From: Town Planning LNE [REDACTED]
Sent: 07 August 2023 14:35
To: Planning
Subject: Ref 6/2023/1421/FULL - retention of two animal shelters and erection of two more, Postern Gate Farm, Newgate Street Village

Network Rail Consultation Response

FAO:	Ms Elizabeth Mugova
Date:	7 August 2023
Application reference:	6/2023/1421/FULL
Proposal:	Retention of two animal shelters and erection of two identical ani
Location:	Postern Gate Farm, Newgate Street Village, Hertford, SG13 8QR

[02] PROPOSED BLOCK PLAN 1:500

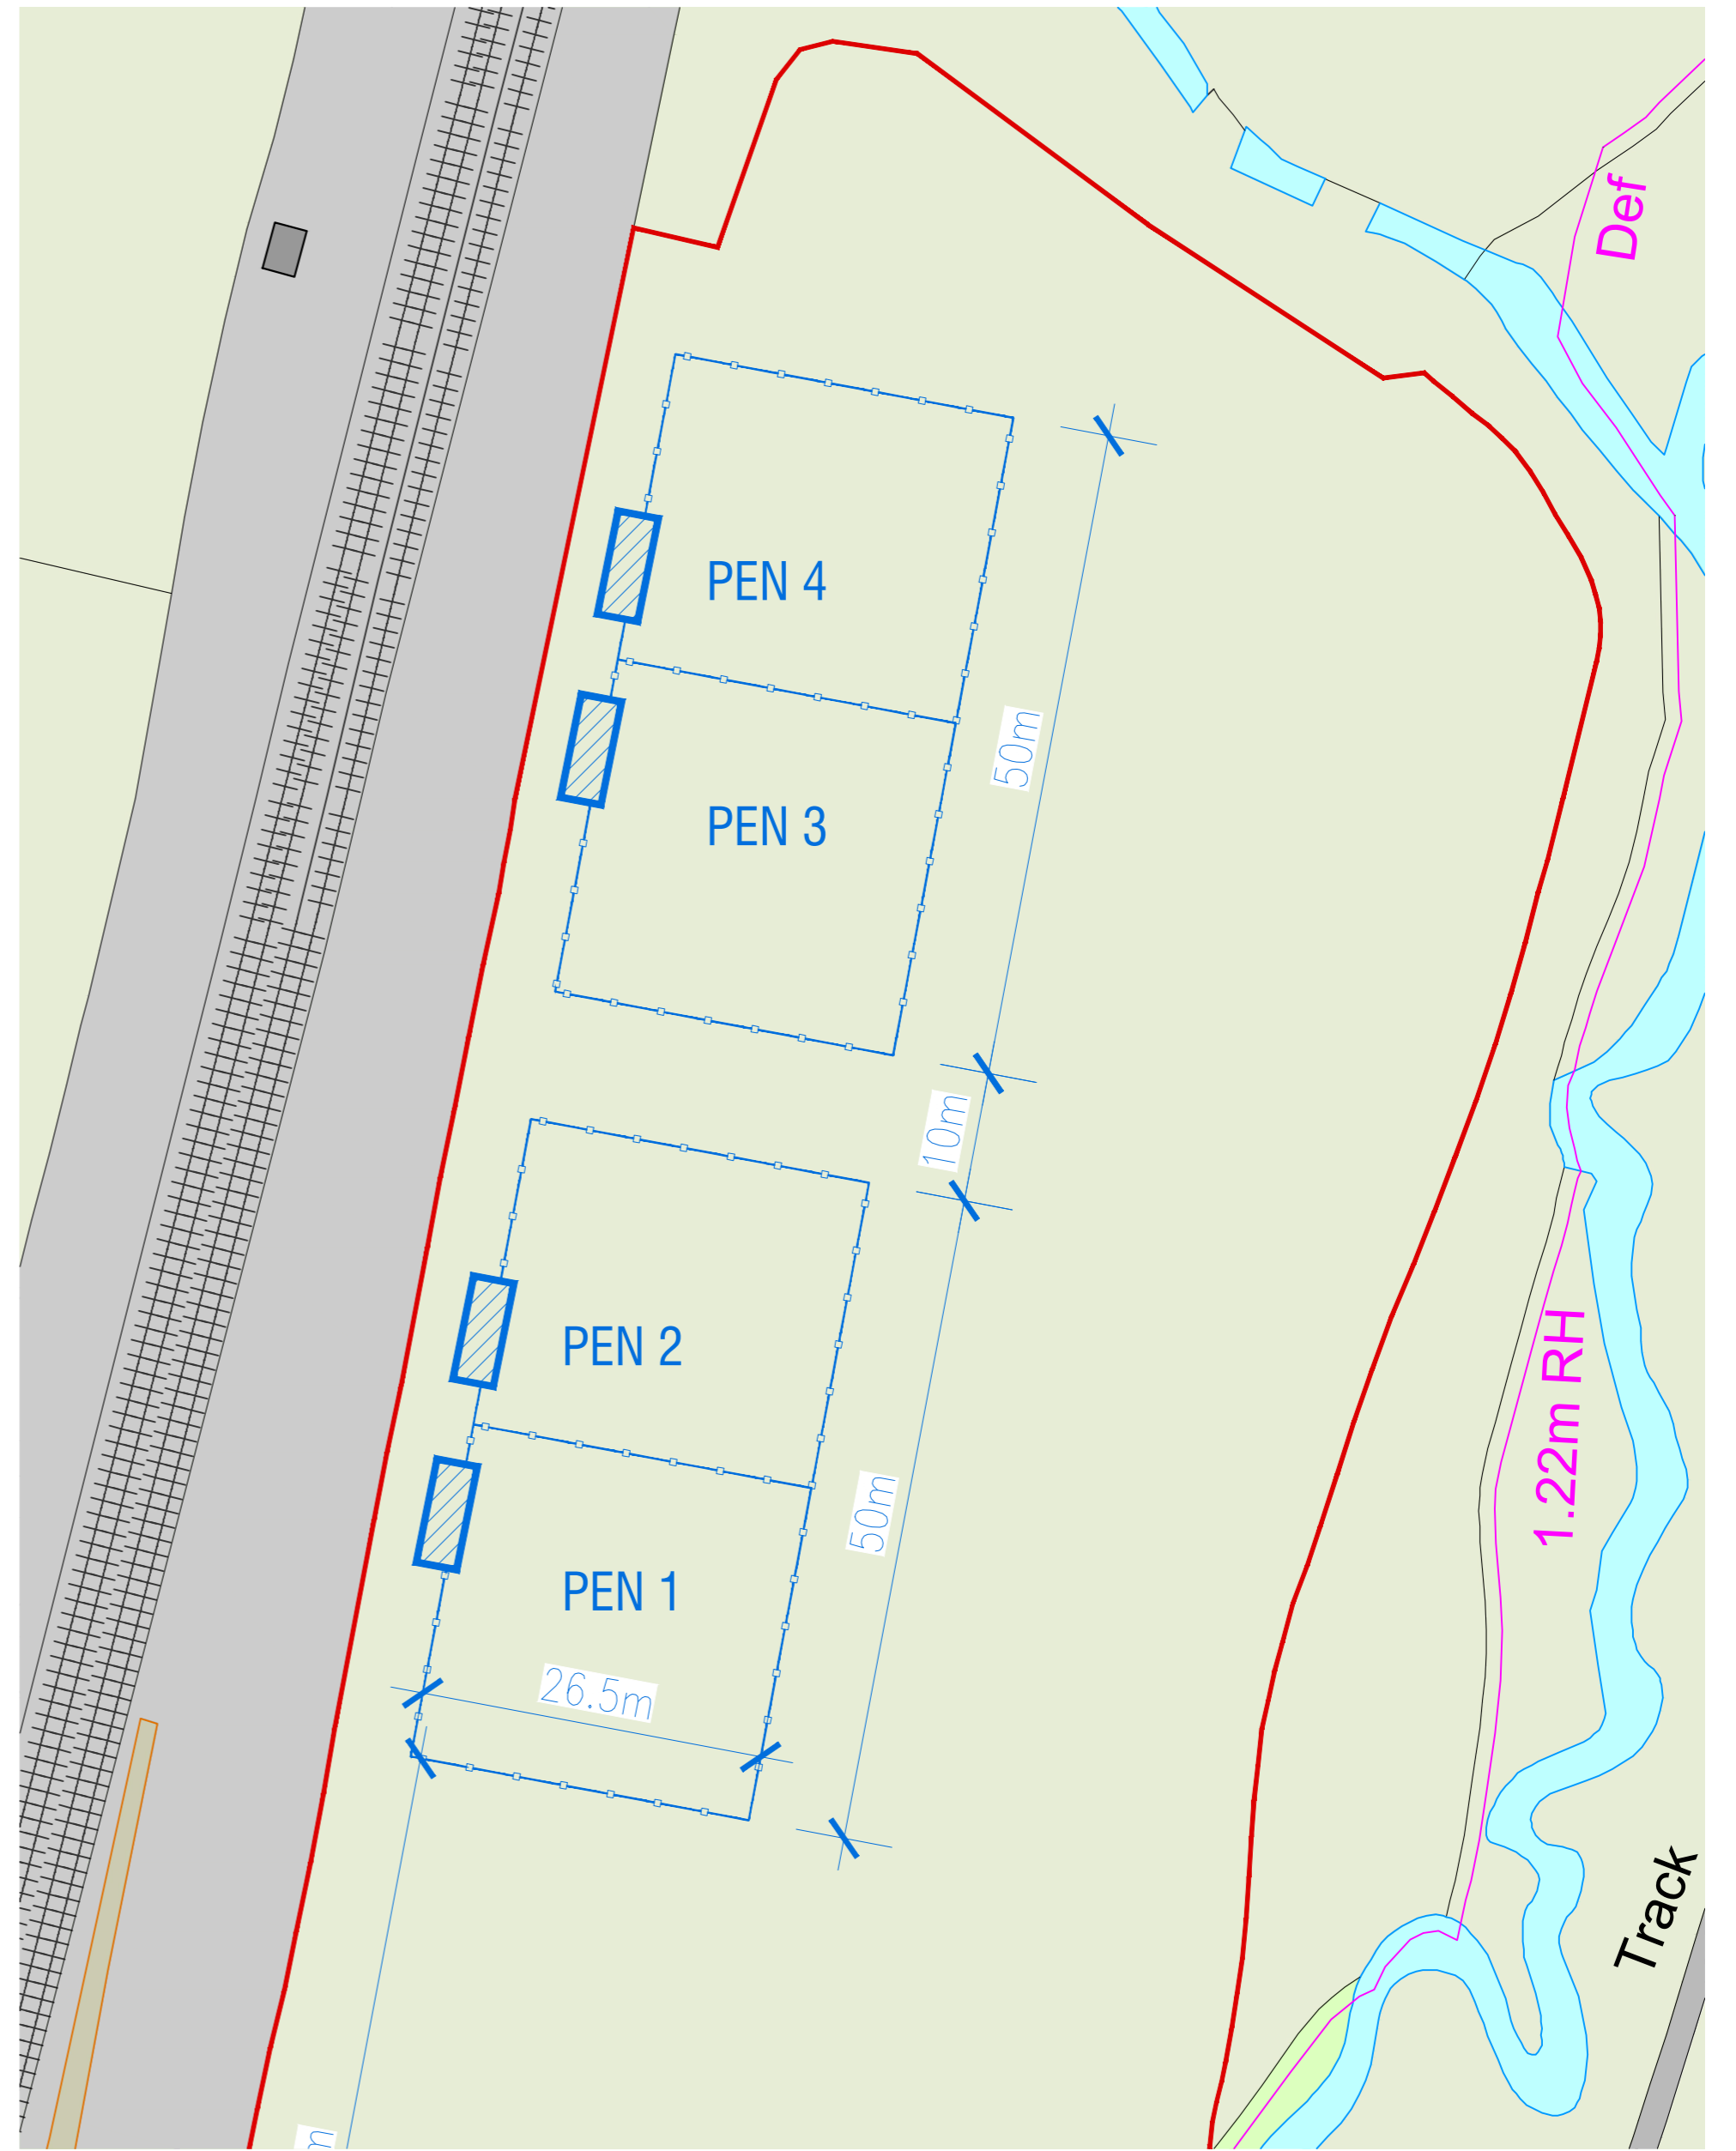
We note the proposals include the provision of pens for animals associated with the animal shelters and the developer should be satisfied that the fencing for these pens is sufficient to prevent animals from escaping into the broader field and potentially onto the railway. The railway boundary fence at this location appears to be post and wire only and not necessarily suitable to prevent animals from getting onto the railway. It should be noted that we are unable to prioritise removal of animals and pets from the operational railway environment and not only is access to the railway highly dangerous, unauthorised access (for instance to retrieve animals) is a criminal offence. The developer should be certain that fencing provision is suitable to prevent this and provide an additional stock proof boundary where this is not the case.
